**Council's Reference: PR.2021.1029**

14 July 2021

**Submission State Significant Development - (SSD-10326042).  
Lot 3 DP 1179941, 241 Gorman Drive GOOGONG NSW 2620**

McPHAIL WAY ELEVATION - NORTHERN END 02  
1:200 011

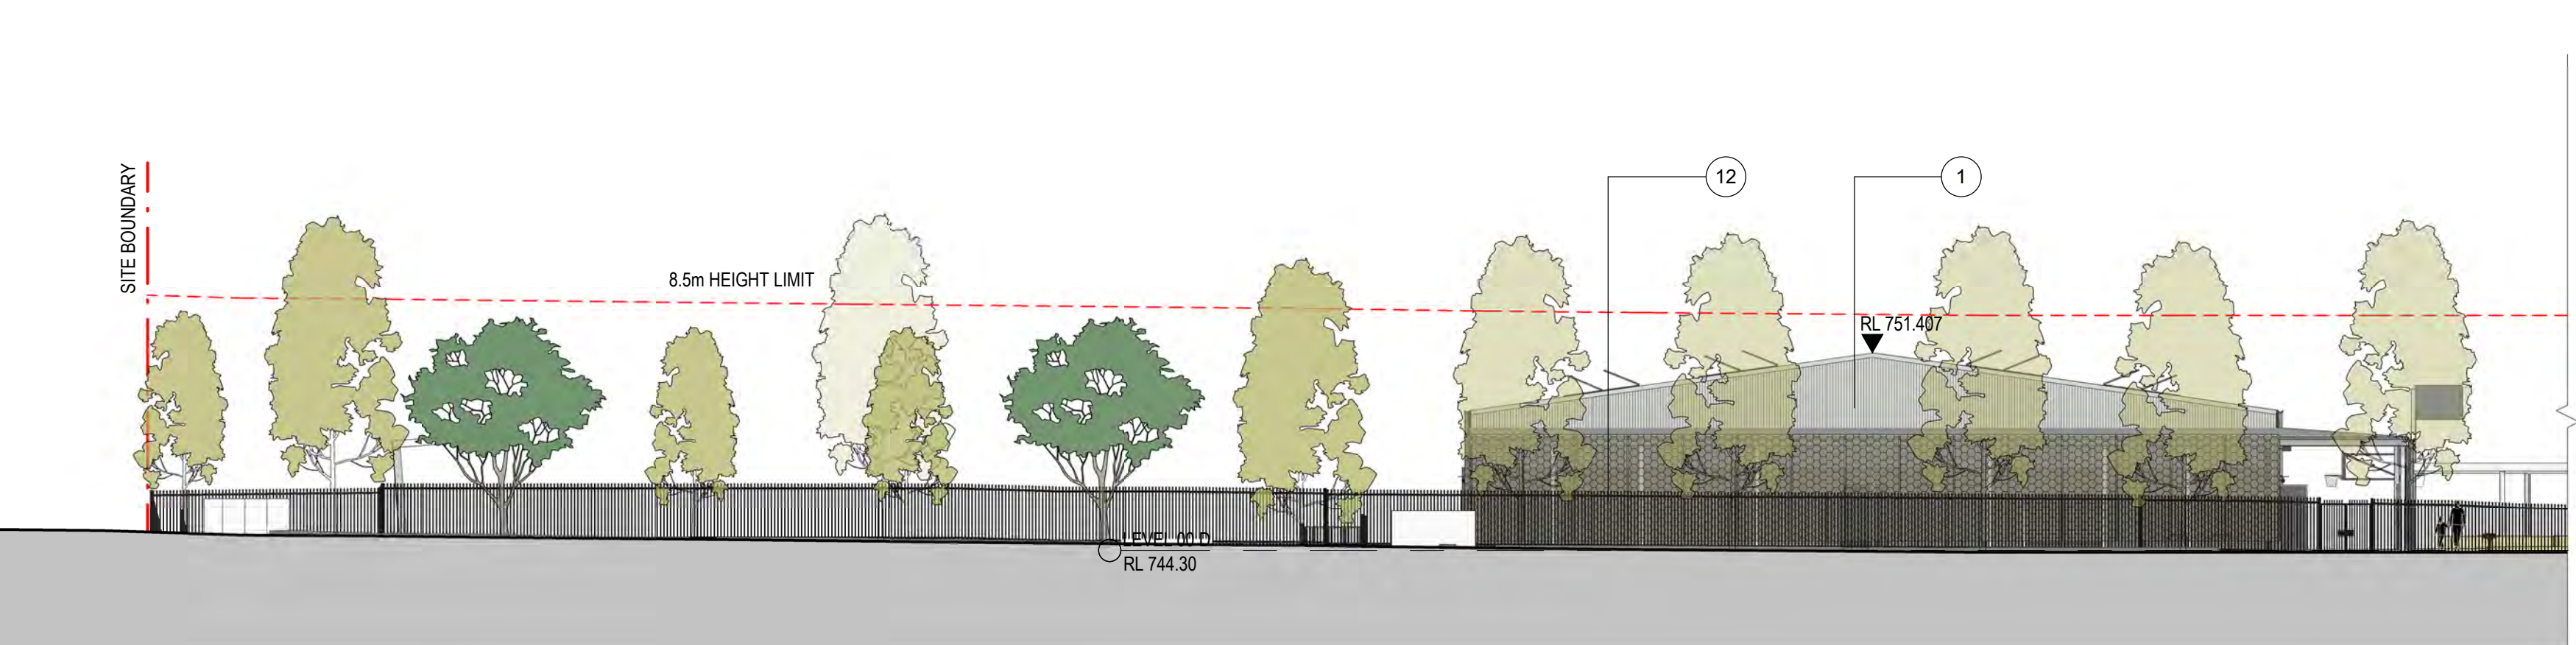
The elevation at the northern end of McPhail Way has a façade that presents a blank wall that could be improved with windows, articulation or change of materials. Landscaping shown on the elevation will soften this portion however, this is not a permanent fix and it is recommended some small changes be made to this building elevation to improve this façade.
